From: Richard McIntosh
To: [Lauren Anderson](#)
Subject: Re: File Nos.: CA017-005, DEV17-009, ADU17-003,SHL17-007, SUB17-004--The Lady Bug Trust
Date: Tuesday, May 30, 2017 2:46:08 PM

We would like to be a Party of Record commenting on the proposed building deviations for the above file numbers for The Lady Bug Trust. We live two lots to the south of the property at 3815 West Mercer.

SHORELINE PERMIT PLAN
SITE PLAN
OGDEN POINT RESIDENCE
THE LADYBUG TRUST
CITY OF MERCER ISLAND, WASHINGTON

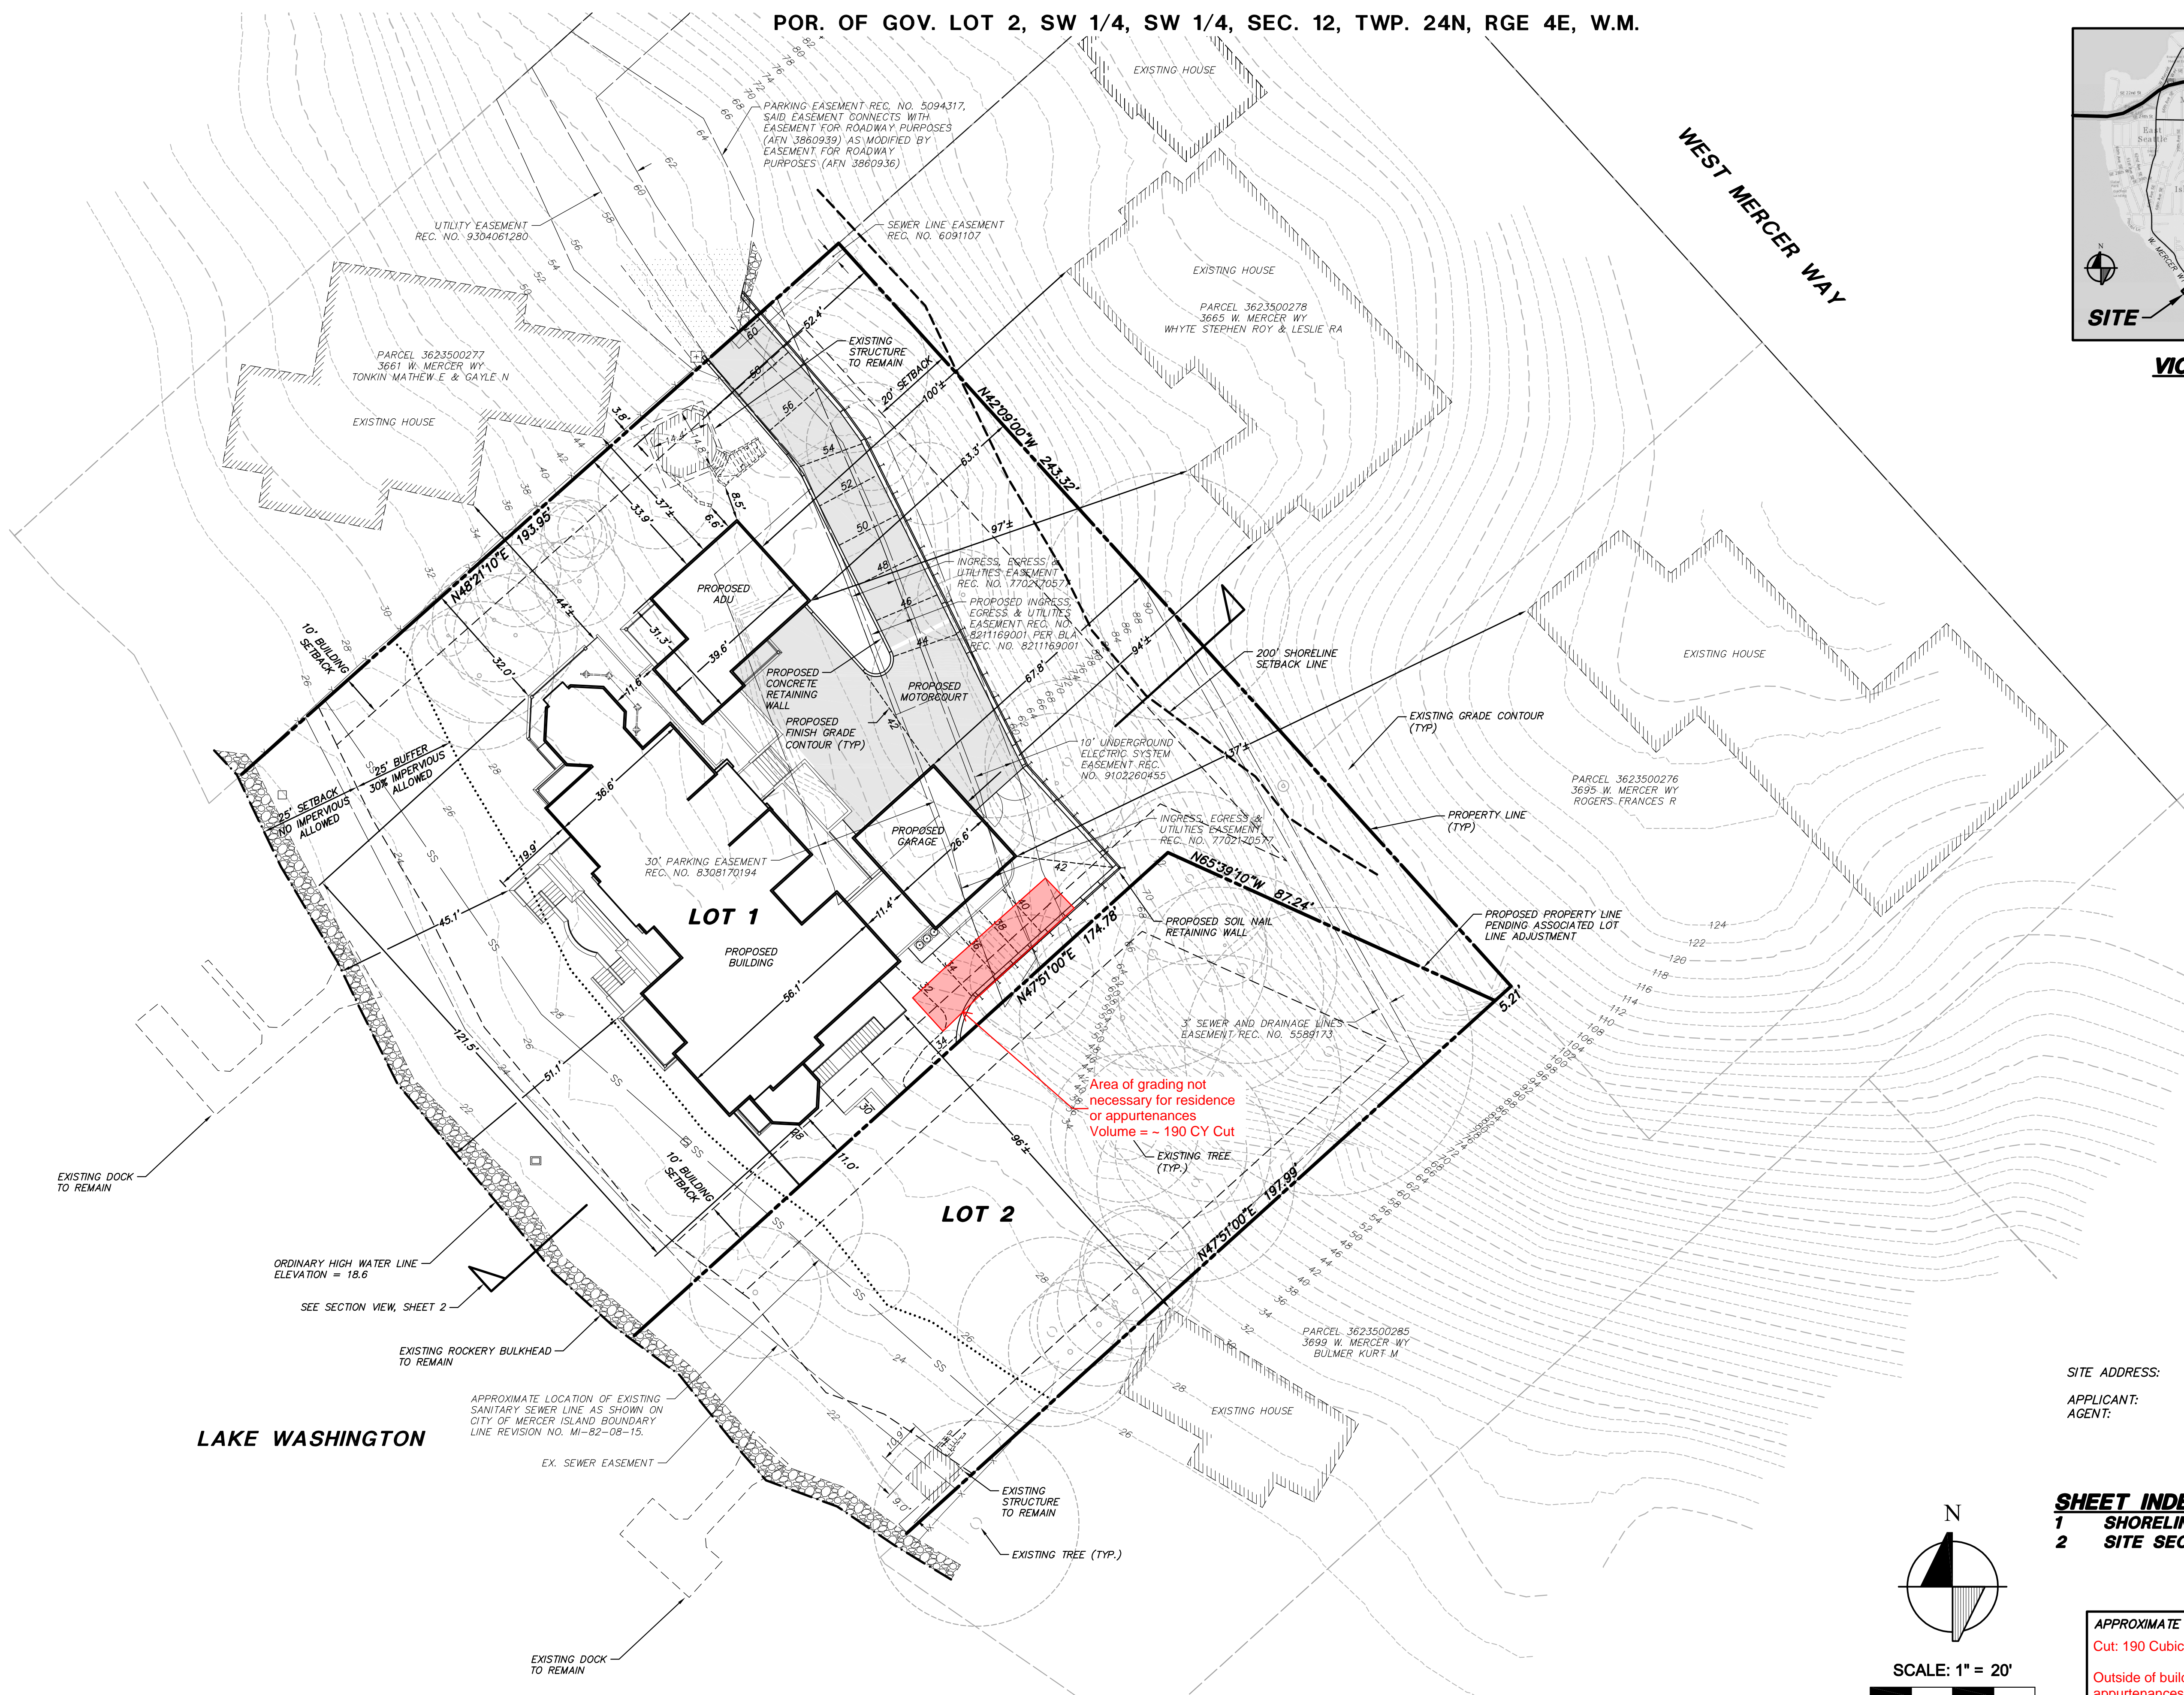
3. Another concern of ours is the deviation requested for altering the steep slope. With slide potential and water run off issues, protecting the vegetation/trees on MI is very, very critical on MI. This extra run off will also affect the shoreline. This property is in MI documented slide area. Our neighbor's property four doors south of us on the Lake had a substantial slide into the Lake this past winter. The constant approval of mega houses is destroying the vegetation that is needed to hold water from our heavy rains. We strongly feel that any more cutting of trees/vegetation should be kept to a minimum. These are two very large lots. Surely a "mega" house can be fit on these two lots without destruction of the steep slope.
